Our Case Number: ACP-323060-25

Re: Mayo County Council Ballina Flood Relief Scheme Compulsory Purchase Order No 1 of 2025 .
River Moy, County Mayo

From a landowner and or occupier of plot T75 as shown on:

Drawing MGW0290-RPS-00-XX-DR-D-WL007-06

Drawing file: Application Documents / Owners_Occupiers Site Notice T75.pdf

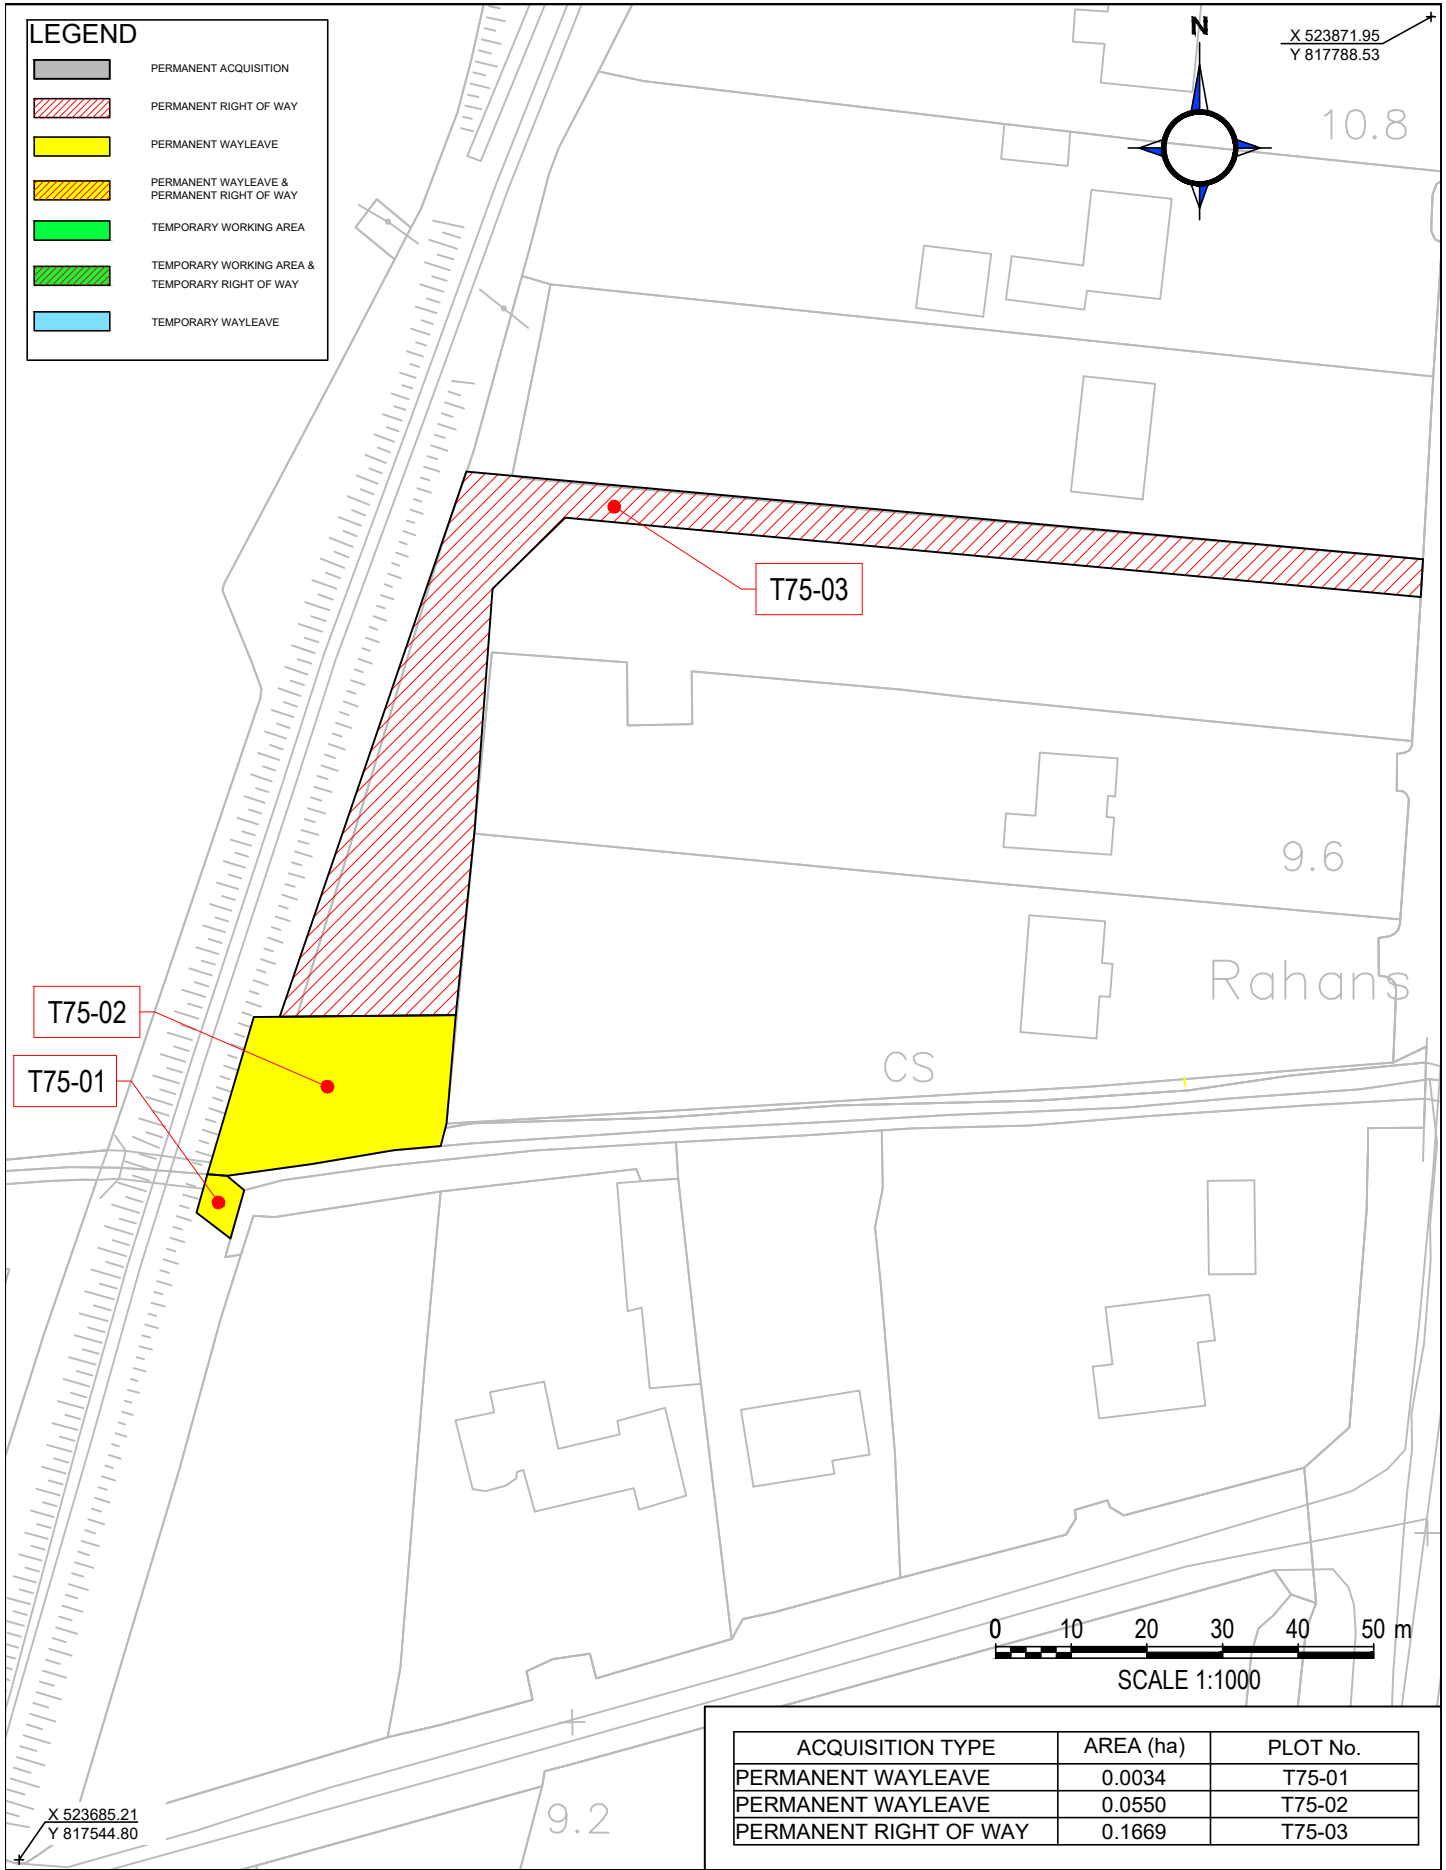
03 Zoning and Future Development: The choice of the site and poor location of the Right of way (T75-03), hugely restricts the future use of the site.

04. Suitability: The Right of way is not actually needed, it is excessive, and a less intrusive route could be used. The land is not suitable for the intended purpose. The ground is uneven with a considerable variation in its topography and levels from the front to the rear of the site.

- The provided access route is aligned along the boundary of my site and causes issues in terms of overlooking and the security of my home.
- No detail has been provided about the use of the lands after the CPO and how this future use will navigate the topography of the site.

- There is a lack of detail provided relating to the design of the proposed access, to the right of way, from the Foxford Rd. to the front of the site. Is this a vehicular or pedestrian route? and what effect will it have on the existing entrance to my house? which will be situated alongside.

- Inadequate detail has been provided on the type of boundary to be provided along the new CPO line.
- Poor consideration has been given to the subdivision of the area of land adjoining my residence. The right of way has been routed along the boundary of my residence. Therefore, this right of way bisects and disconnects the land from my house. This land was purchased to be an additional amenity to my long-term home. The location of this right of way will essentially deny me access to this area of land from my own home.

No drainage details have been provided along the permanent right of way, and where this area will drain to. No details have been provided as to the type of paving etc. to be provided on the right of way.

No detail has been provided about the use of the lands after the CPO and how this future use will navigate the topography of the site. Will substantial earth works be required? how will this affect both my home, the surrounding drainage and the remaining area of land, left after the establishment of the right of way?

The house directly beside the stream (indicted as D1), it is proposed it will have permanent wayleave along the side of the house, right at the stream boundary. It makes more sense to have access here. The ground is level and flat with a sizeable entrance to the site. The distance would only be approx 25 metres to link to the permanent way leave in comparison with the lengthy and unnecessary proposal across our lands. Please see photo 009.
